Comments on Response to Submission report- Mt Pleasant Operation (DA92/97)

Thank you for your email of 19 June 2017 inviting the Environment Protection Authority (EPA) to provide comment on the modification application, DA92/97 MOD3, submitted by MACH Energy Australia Pty Ltd. I note the modification seeks to extend the life of the open cut mine by six years, to 2026, extend overburden and waste rock emplacement areas and other associated amendments to approved final landform design.

The EPA has reviewed the document titled, '*Mount Pleasant Operations – Mine Optimisation Modification – Environmental Assessment*', dated 31 May 2017 prepared by Resource Strategies Pty Ltd (Modification EA).

Figure 3 Site Catchment and Drainage Plan 30/9/2018

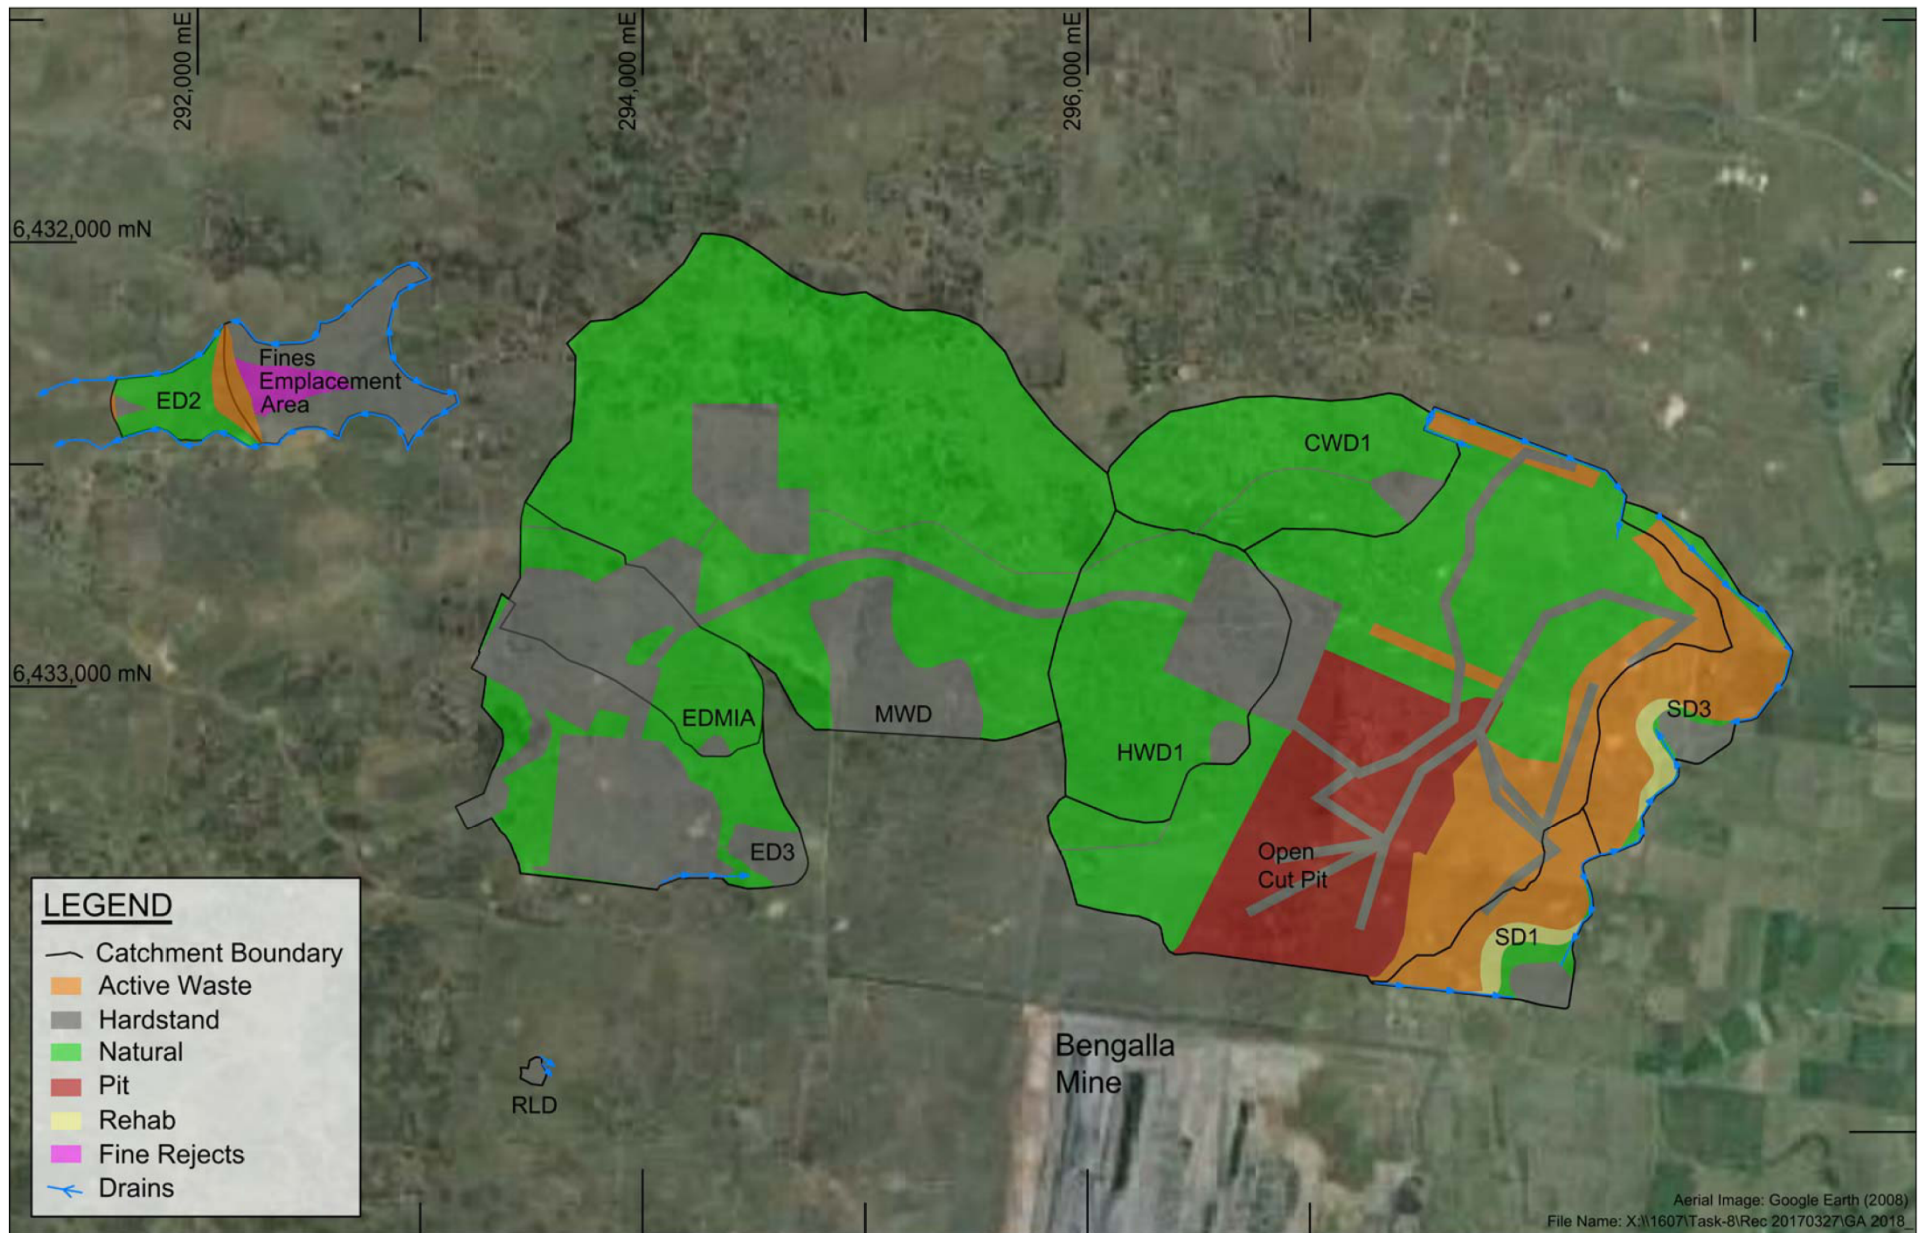
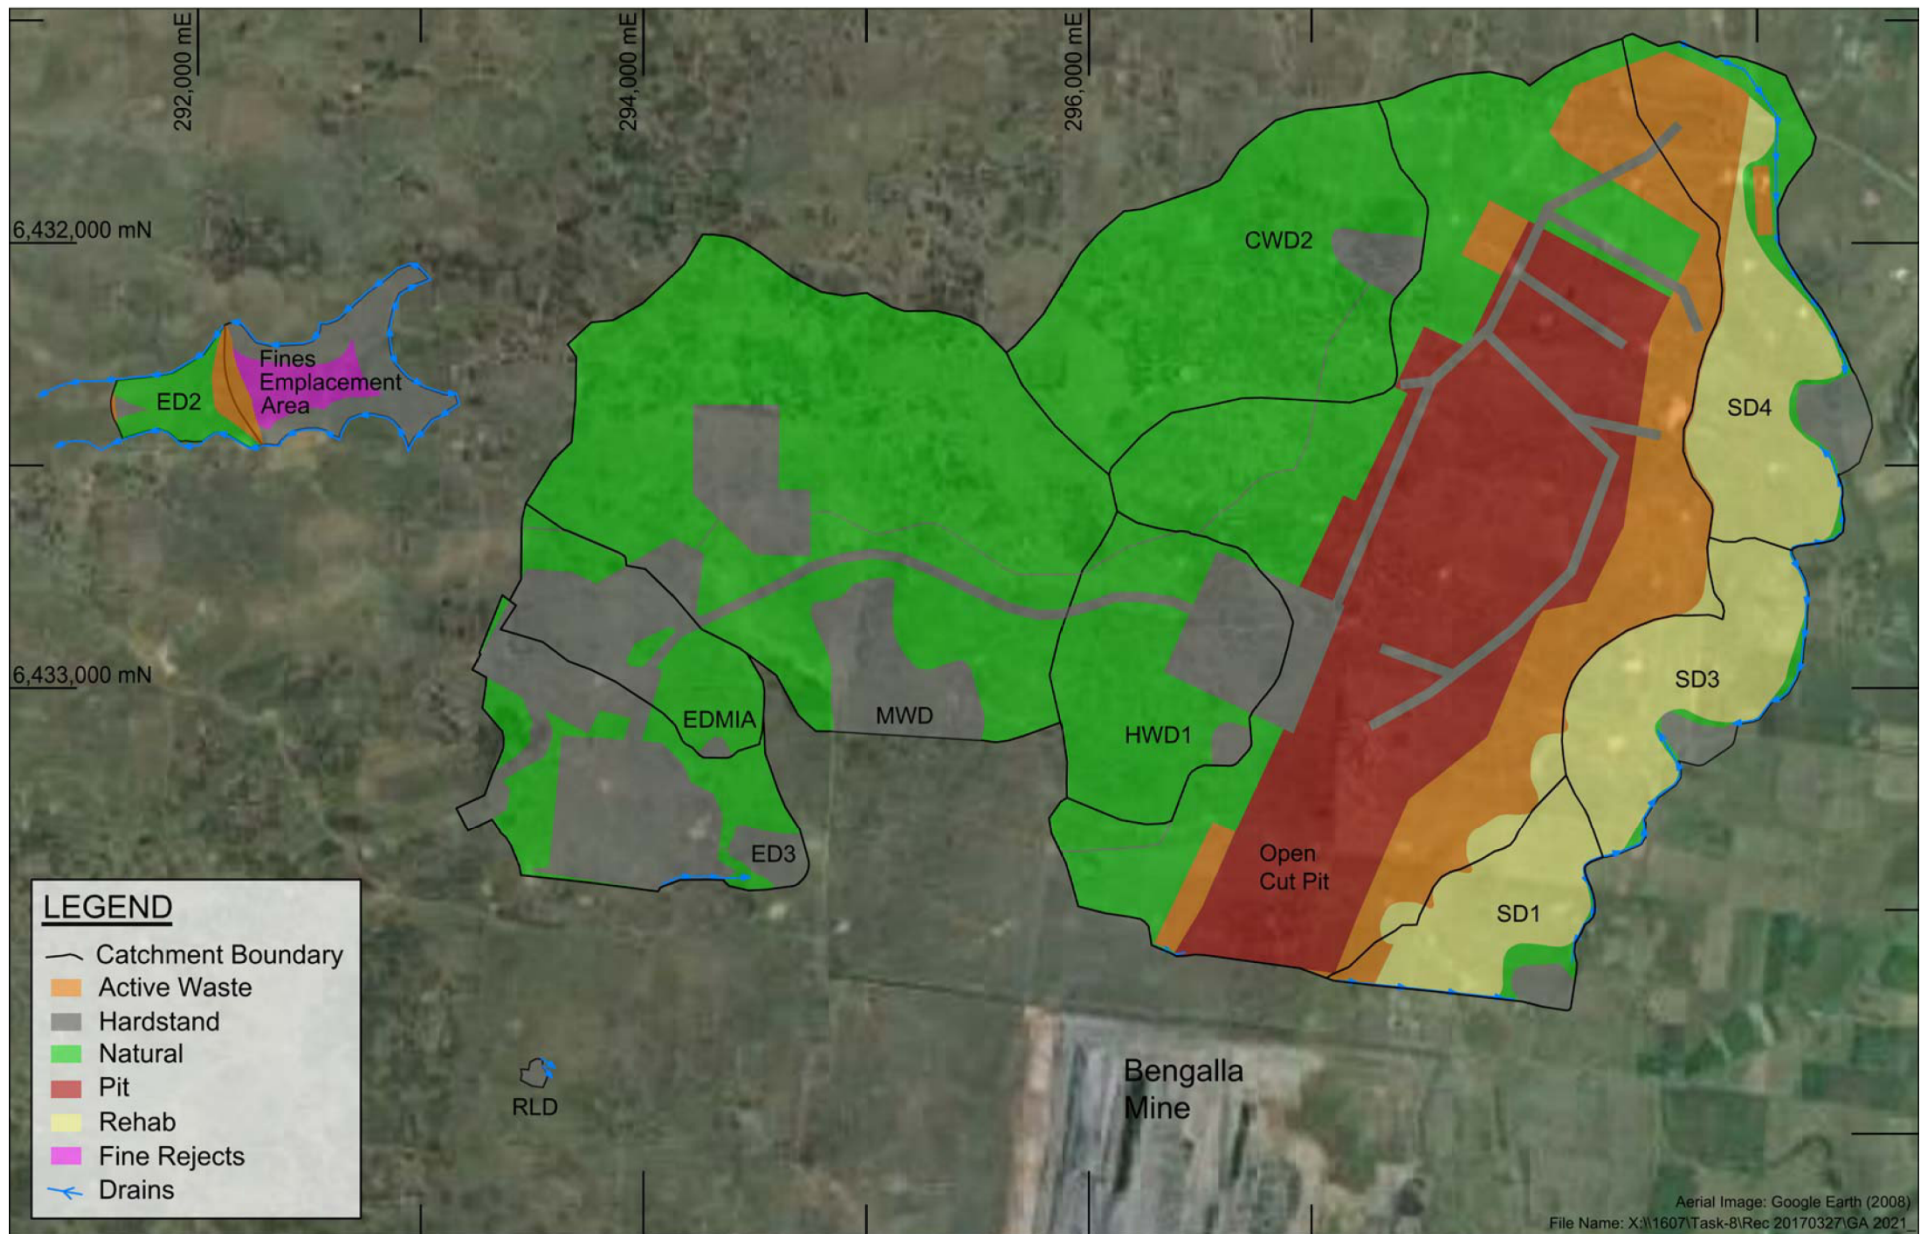
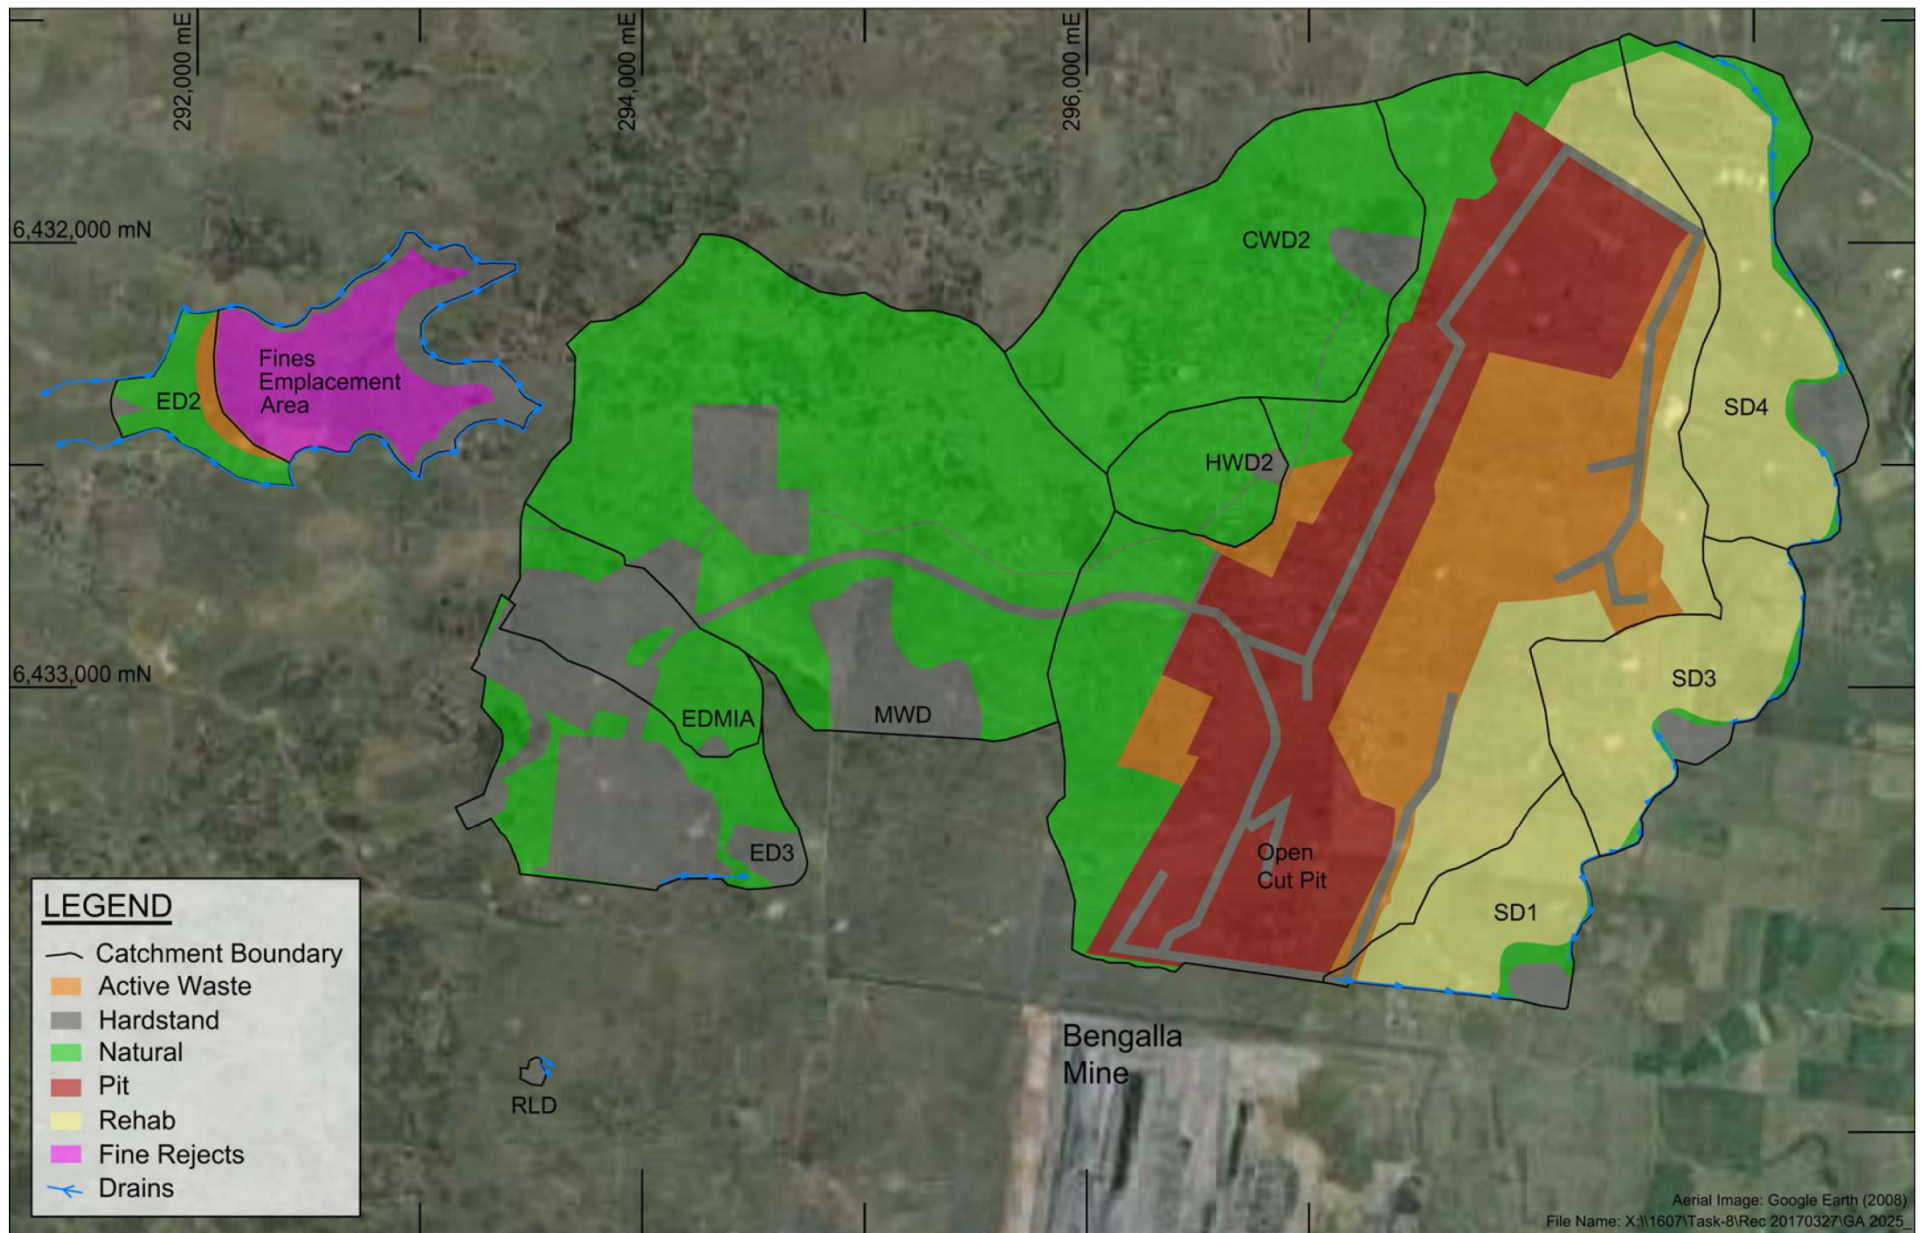
Figures 3, 4 & 5 of Appendix E (under section 2.2, pages 7-9) in the Modification EA show a layer of 'active waste' in between the FEA and Environmental Dam 2. Active waste is not defined within the Modification EA or previous consent documents. Further information is requested stating the definition and characteristics of 'active waste'.

The EPA also requests further information regarding the design criteria of the FEA. Due to the hazardous nature of material being stored in this area, further clarification is sought to ensure the risk of any discharge is mitigated.

Figure 6 Water Management System Schematic

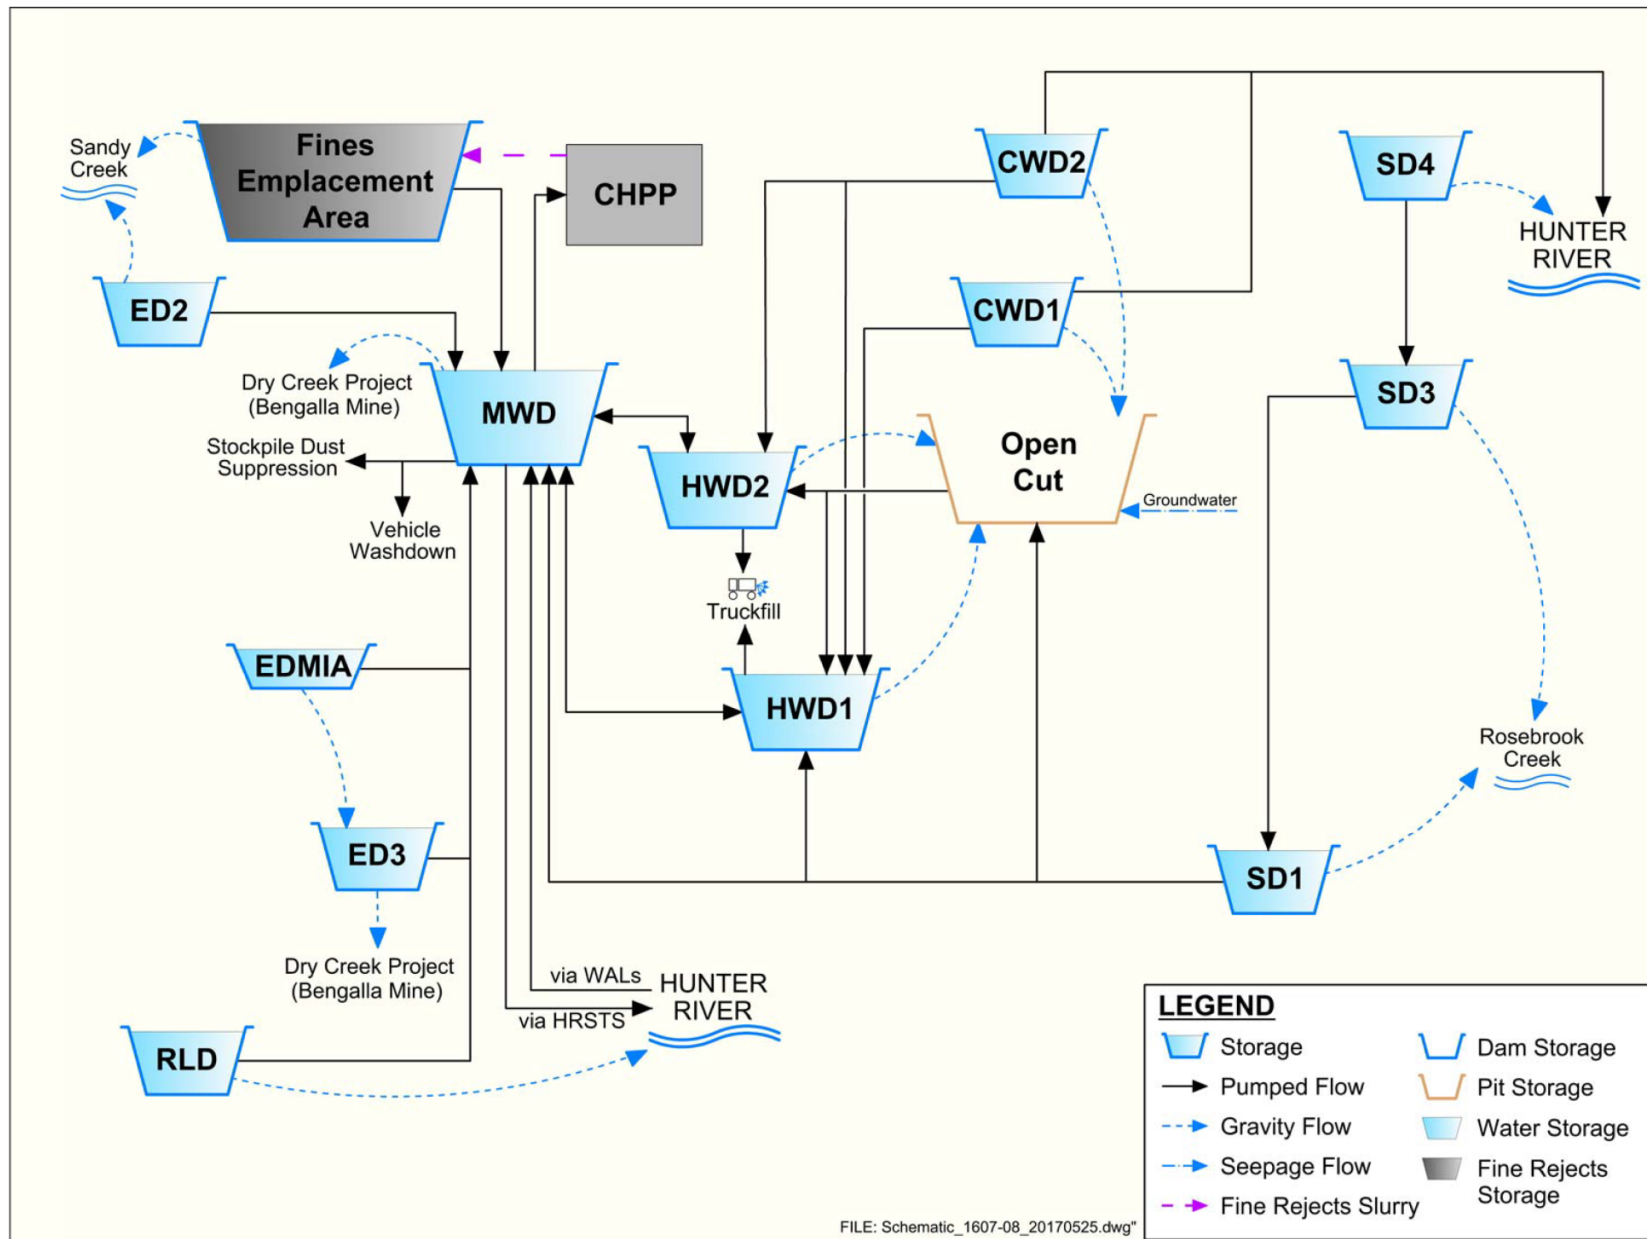
There are discrepancies between the water management system schematics (the schematics) in the modification, presented in Figure 8 in the main text (under section 2.8 on page 16), and Figure 6 in Appendix E (under section 2.2 on page 10). Figure 6 indicates a discharge from the Fines Emplacement Area (FEA) to Sandy Creek while this is not identified in Figure 8. The EPA does not support the discharge from the FEA offsite due to the potential quality of the water and associated contaminants. The proposal should ensure that all discharges from the FEA area are collected and fully contained within the premises.

Appendix E also suggests a discharge will occur from the Mount Pleasant premises to the Dry Creek Project (Bengalla Mine), however this is not discussed or identified within the main body of the Modification EA.

These discrepancies should be clarified to ensure the water management system to be implemented is adequately assessed and documentation demonstrates the water management system will not have a significant impact on receiving environments.

The Modification EA schematics (Figures 8 & 6) show discharges from many of the sediment dams to the Hunter River, Sandy Creek and Rosebrook Creek. Currently the Licence does not permit the discharge of water from the premises. Further information is needed to justify the nature and frequency of discharge(s) and the intention with regards to identifying discharge points on the Licence.

The Modification EA references 'overflow due to rainfall in excess of design criteria', however, the design criteria are not specified within the Modification EA. The design criteria for each dam is requested. Additional information is also sought on the frequency, volume and expected quality of
